Demolition of existing dwelling & the erection of 7No. residential dwellings, with associated parking, amended access location from Lime Tree Close & landscaping.

Scorton 9 Lime Tree Close East Preston

Thank you for your internet representation made on 28th April 2018 which has been recorded as **'an objection'** with the comments as follows:

The Pure Group
Limetree Close East Preston
Plot 5 & 6: Limetree Cottages. Proposed Elevations, Floor Plans, Roof Plan & Section
Drawn by: AM The Pure Group
Drawing ref: LTC.PLOT5&6.001
Planning Issue: March 2018. Scale as Bar
www.thepuregroup.info

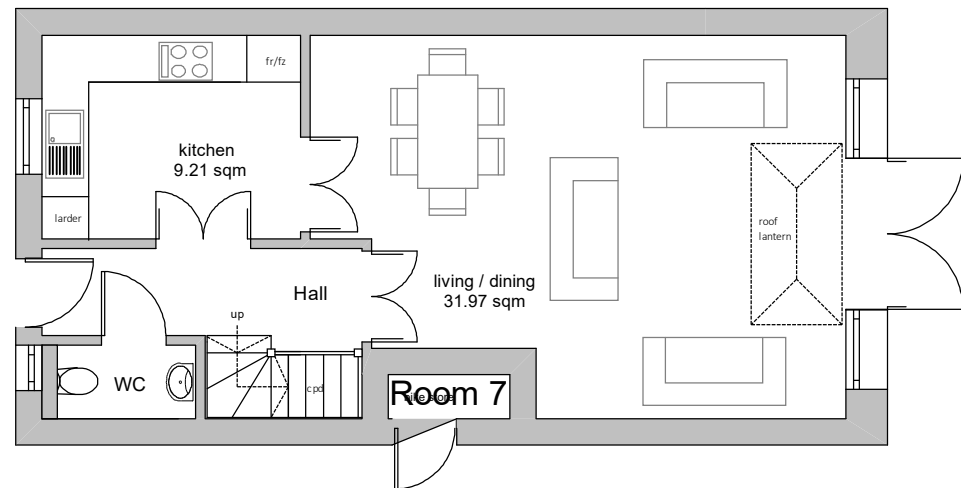
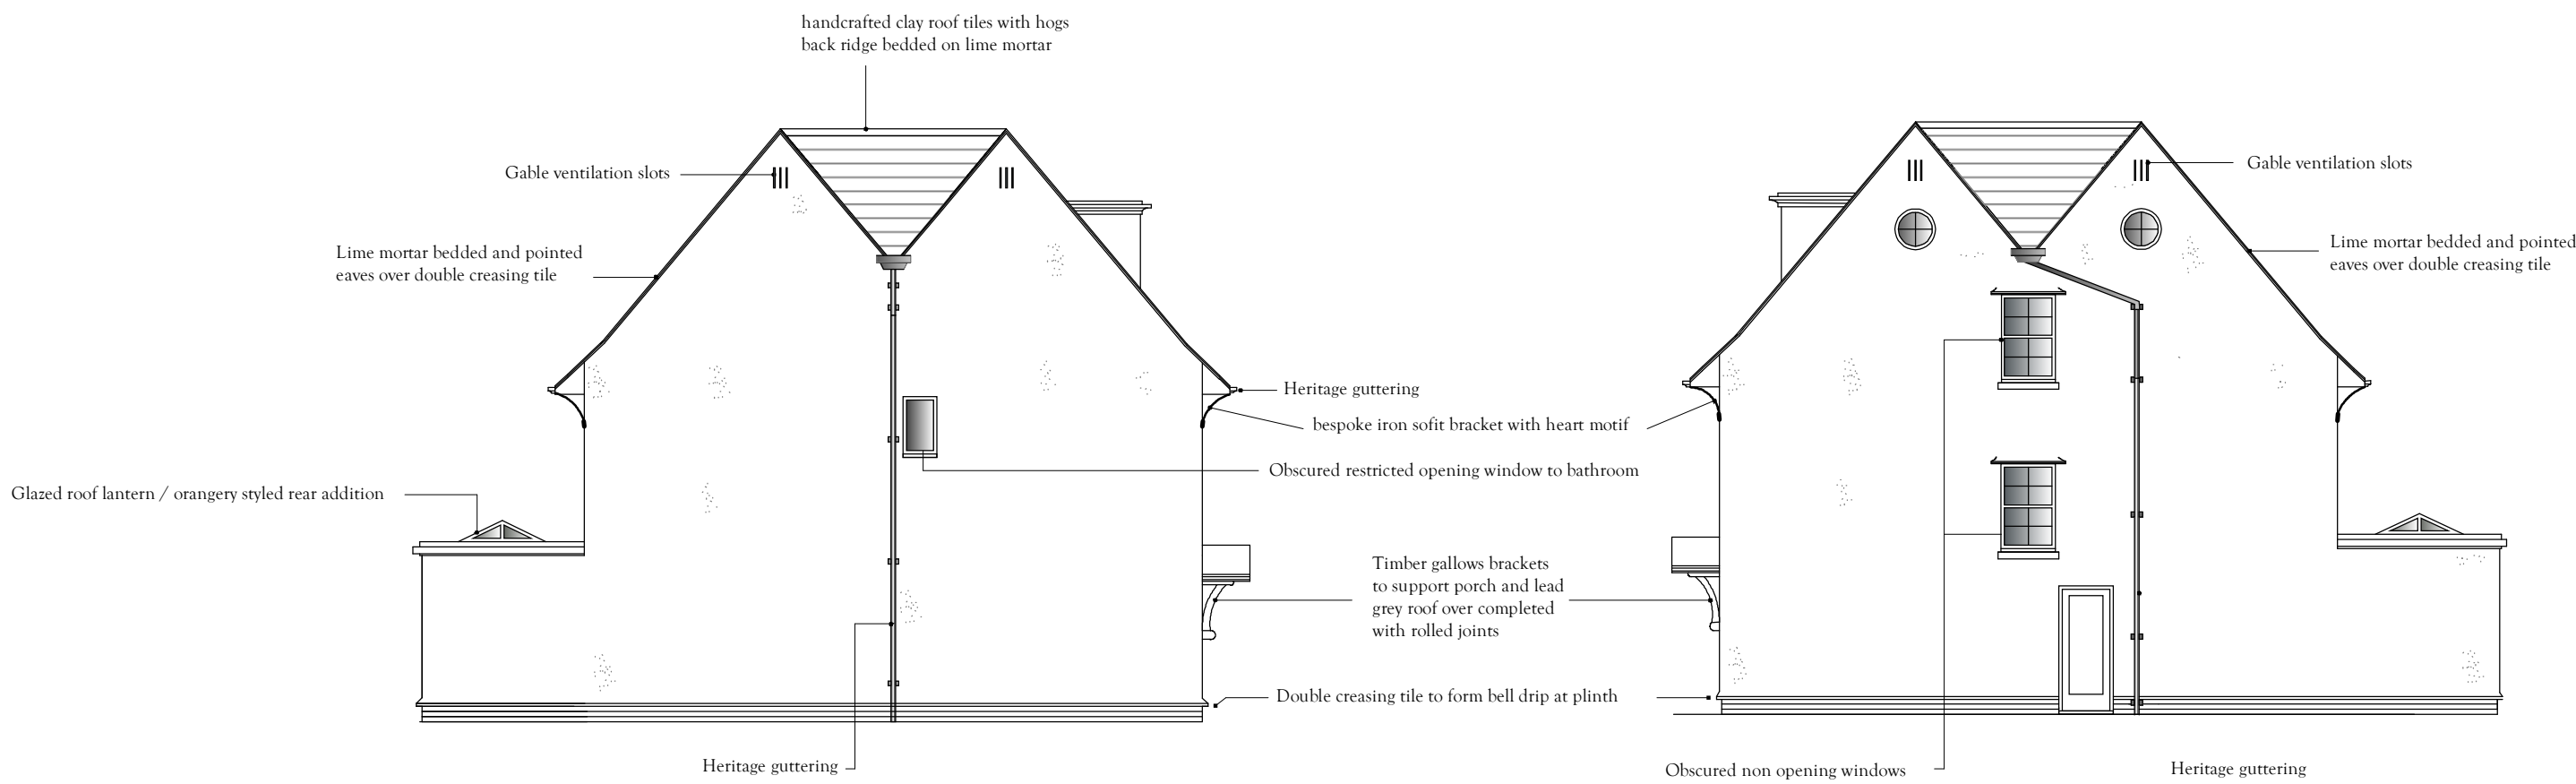
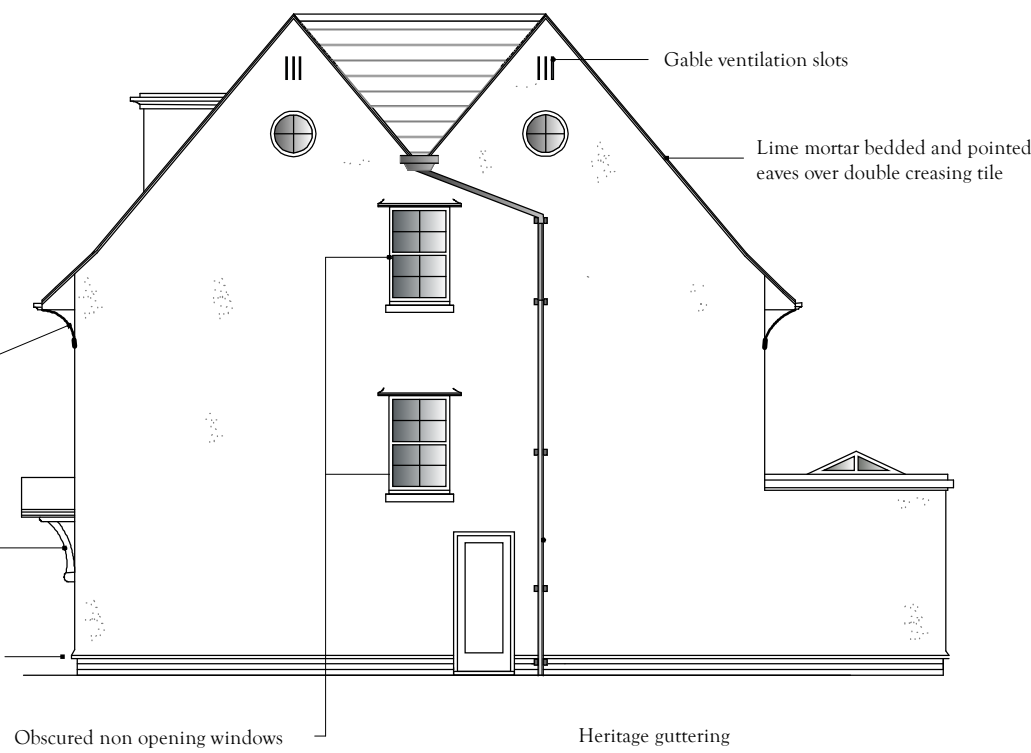
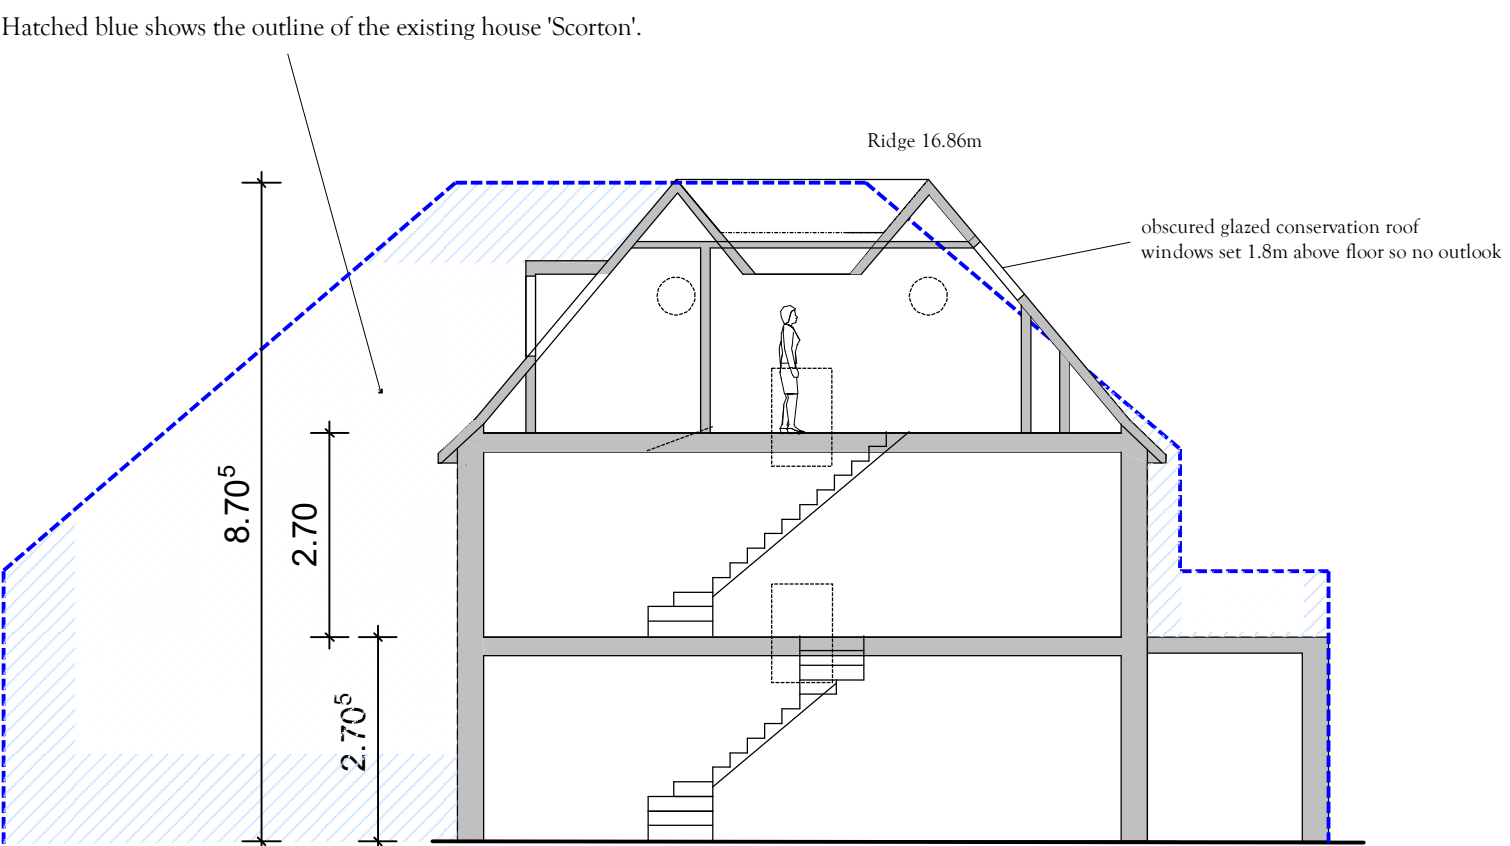
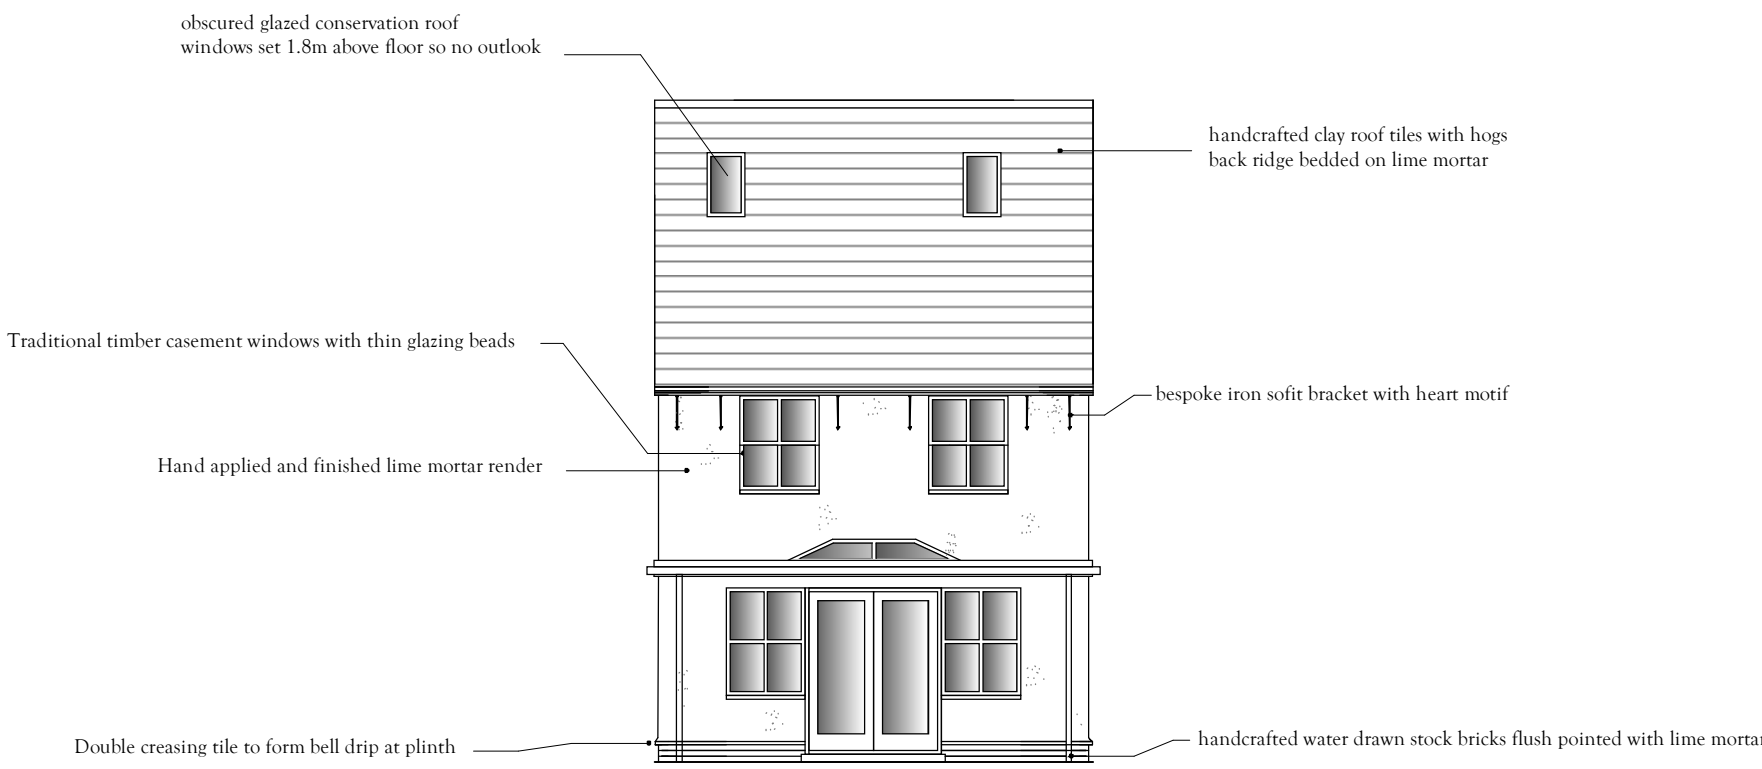
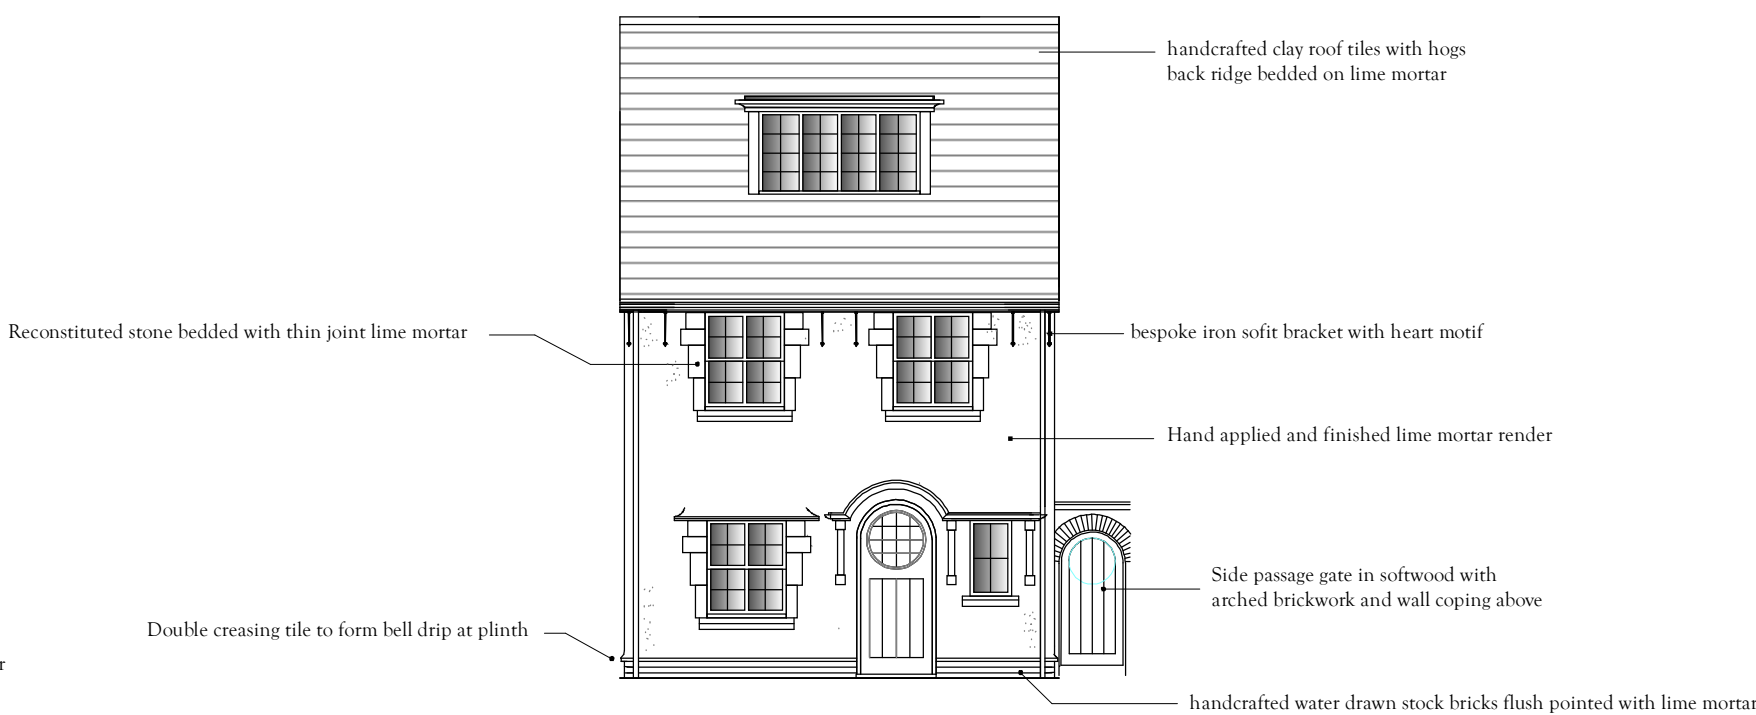
Comment 2. We note from the wording on the plans that the developer assures us the proposed new houses will be the same distance away from the boundary as the existing house, and be the same height. However - the plans show three storey houses with windows in the roof level. Currently our rear garden is not overlooked by the existing old house yet this proposal seems to show a row of four new houses with 2nd floor windows able to look down on us.
